Application No: CM/44/20/DOC
Site Address: Land adjacent to Scyld Horsemere Green Lane Climping BN17 5QZ
Description of works: Approval of details reserved by condition imposed under ref CM/21/19/PL relating to Condition No 8 - Construction Management Plan.

Thank you for your internet representation made on 25th November 2020 which has been recorded as no objection with the comments as follows:

Site Compound  
Plan  
Title:  
Drawing:  
Scale:  
Date:  
Author:  
Check:  
Drawn:  
Date:

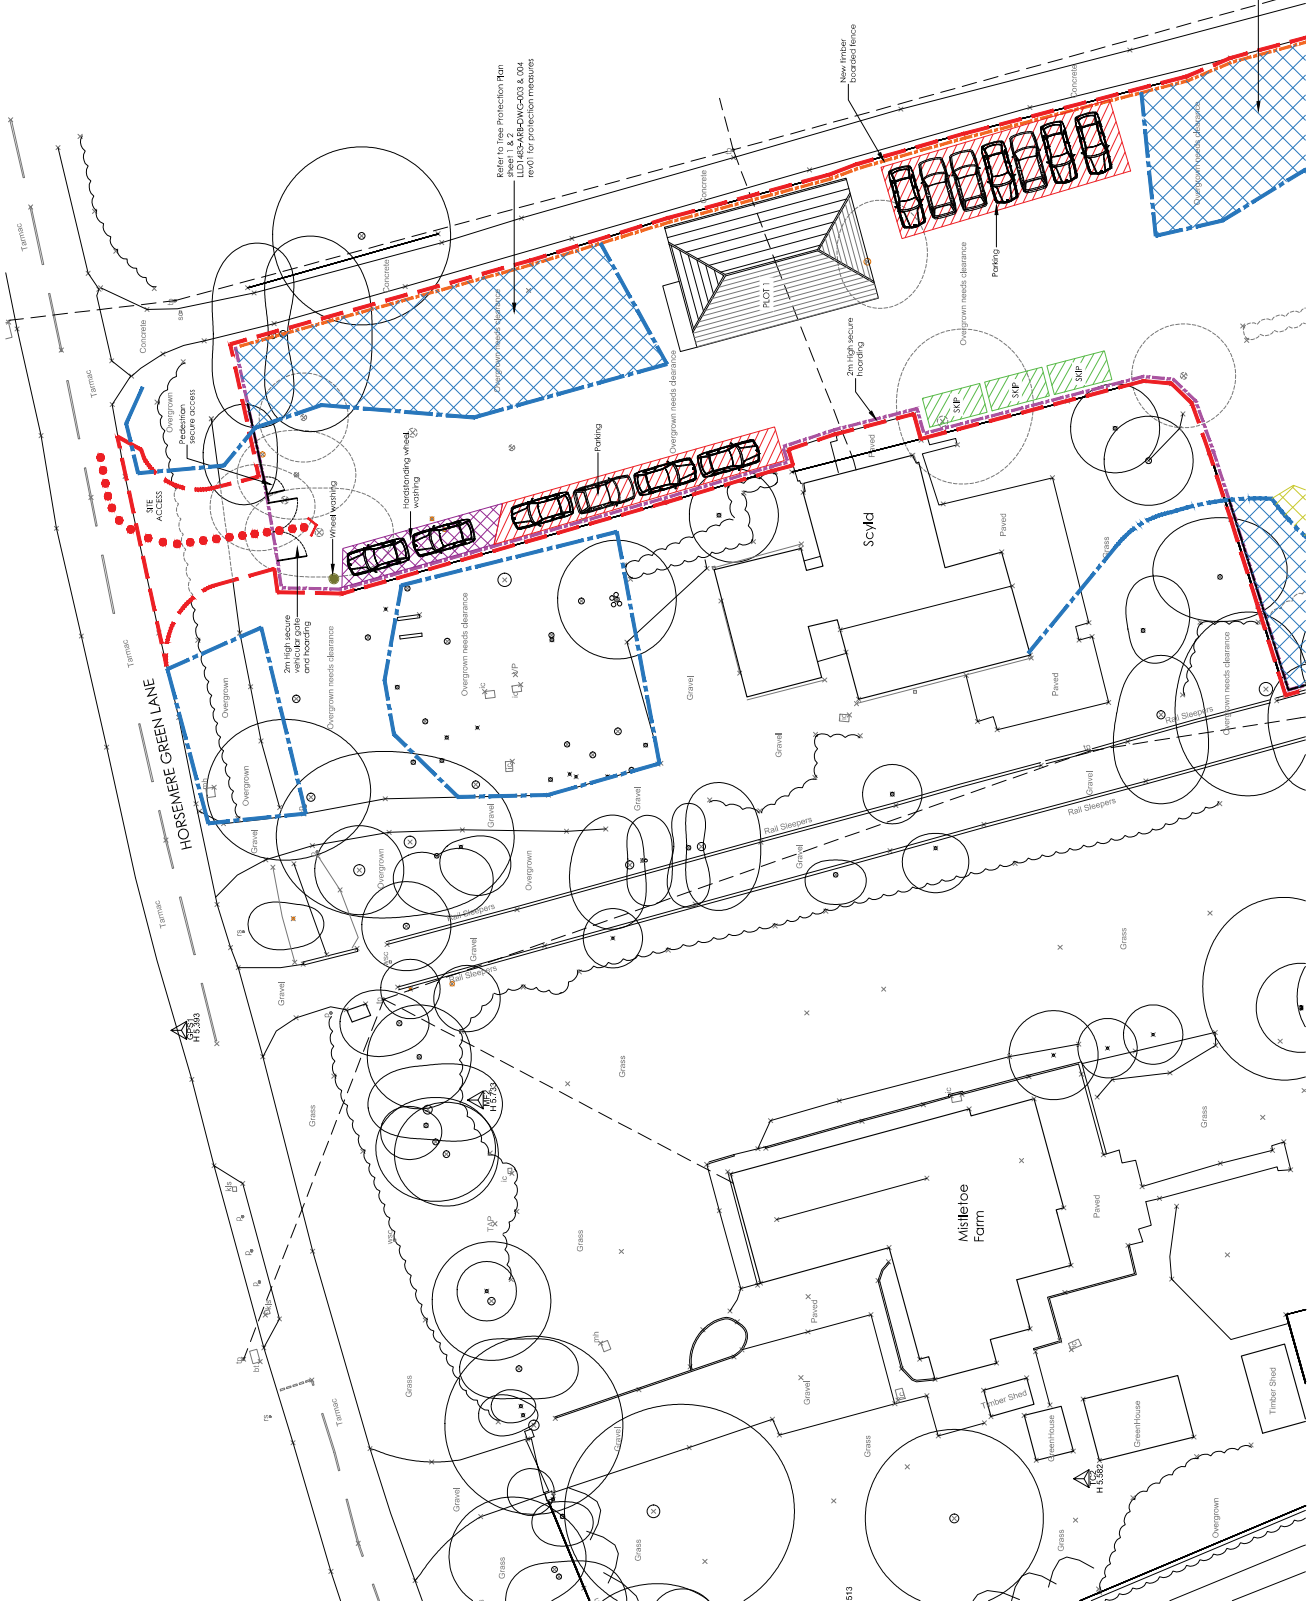
I would like the developer to make note that Scyld owns a land boundary on the east of the property that includes 2 metres from the most eastern part of the property. Therefore I would like to ascertain that the developer does not intend to build on that land or remove any trees that fall outside my fence, but inside my boundary.

I also note the plan does not include working hours.
